Our reference: LIC07/80-12
Contact: Samantha Wynn, 02 68 835 330

I refer to the Project Application, Environmental Assessment (EA) and accompanying information provided for the proposed Northparkes Mine Extension Project (ref MP 11_0060) received by the Environment Protection Authority (EPA) on 8 July 2013.

The EPA has reviewed the information in the EA and has determined that it is able to support the proposal subject to the proponent addressing the information requirements outlined below and in **Attachment A**. **Attachment A** also contains the EPA's assessment of the proposal, including justification for the amendments and request for additional information.

Assessment of the Proposal and Request for Additional Information

Conceptual Cross Section Typical TSF Construction

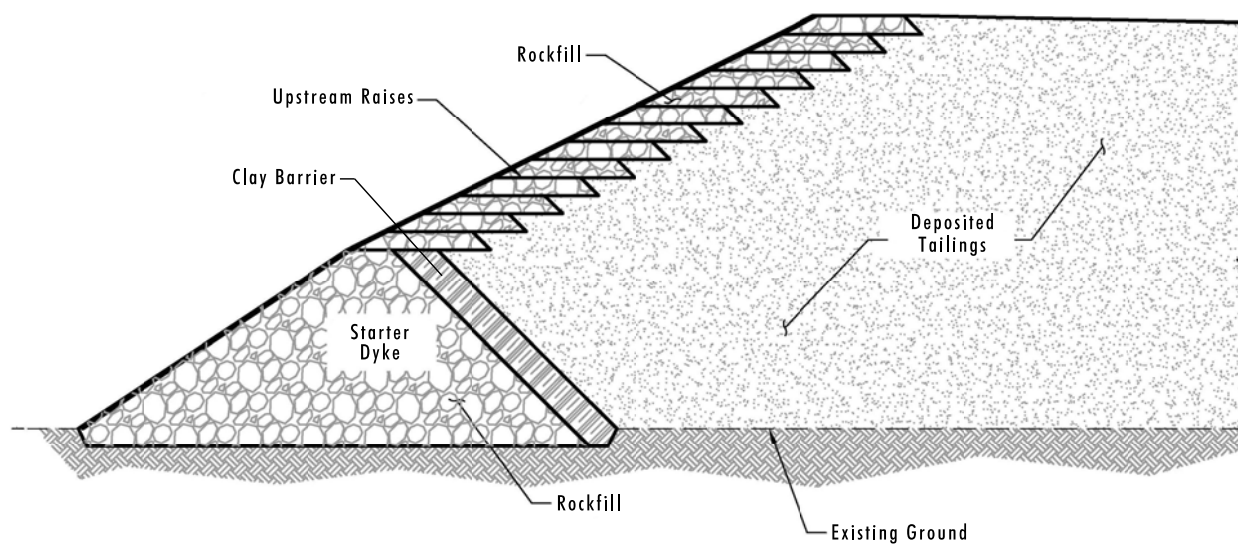
The EA does not appear to provide detail on how the Tailings Storage Facility (TSF) extension will be constructed and whether the TSF will be lined and if so details of the proposed liner to ensure pollution of surface water and ground water does not occur.

- Further information regarding the construction of the clay liner (or alternate geosynthetic liners) for the TSF extension is required. This includes the location of liners (e.g. floor and walls), overall thickness of liners, thickness of successive layers, gradients of sides of structures of clay liners etc for all structures. Alternatively impermeable geosynthetic liners could be considered.
- Further information is required to demonstrate how the EPA's clay liner requirements for contaminated water storage structures (outlined below) will be met to ensure impacts do not occur.

Approved Conceptual Water  
Management System

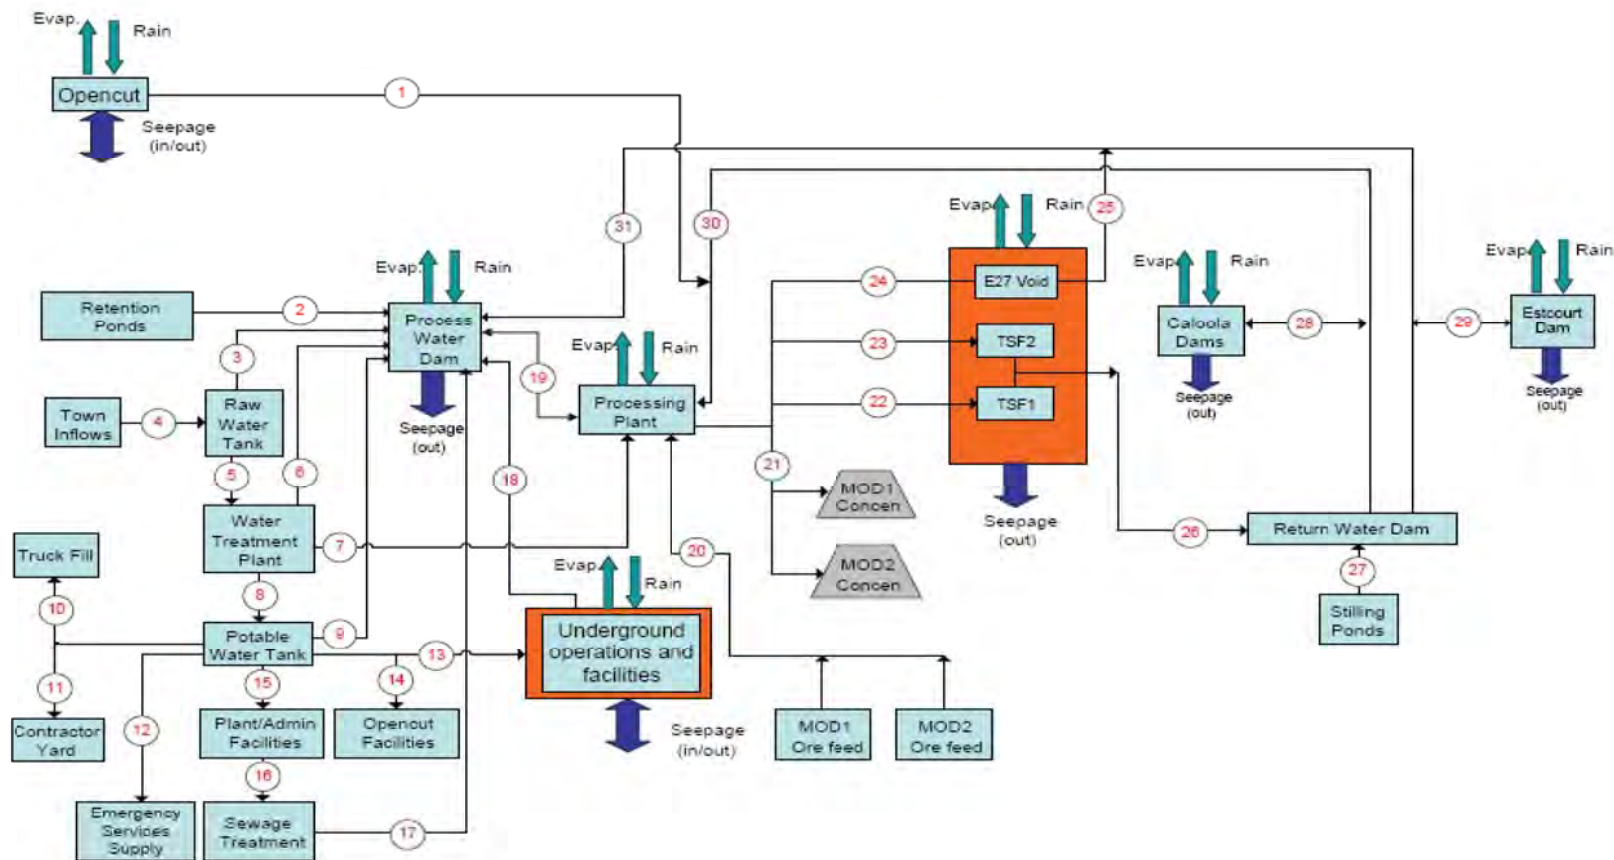
The dirty water system captures runoff from the stockpile areas and tailings dam walls in sediment basins. The basins have been designed to intercept runoff generated by the 90th percentile 5 day duration rainfall event. The Surface Water Assessment states that runoff collected in these basins 'must be of sufficient quality prior to being discharged off site into surrounding natural watercourses' and 'any controlled discharges from the sediment dams will be of a quality consistent with the requirements of the 'Blue Book'.

Note that the 'Blue Book' recommendation for discharge of collected water at 50 mg/L total suspended solids relates to water that is otherwise uncontaminated. Water collected in the dirty water system at Northparkes contains elevated levels of pollutants.

It is unclear what storm event the contaminated water system has been designed for and the design capacity of all components of the contaminated water system.

- what storm event the contaminated water management system has been designed to capture and contain runoff for; and
- details (including design calculations where appropriate) of all components of the contaminated water system to support the statement that the contaminated water system is a 'closed circuit'.
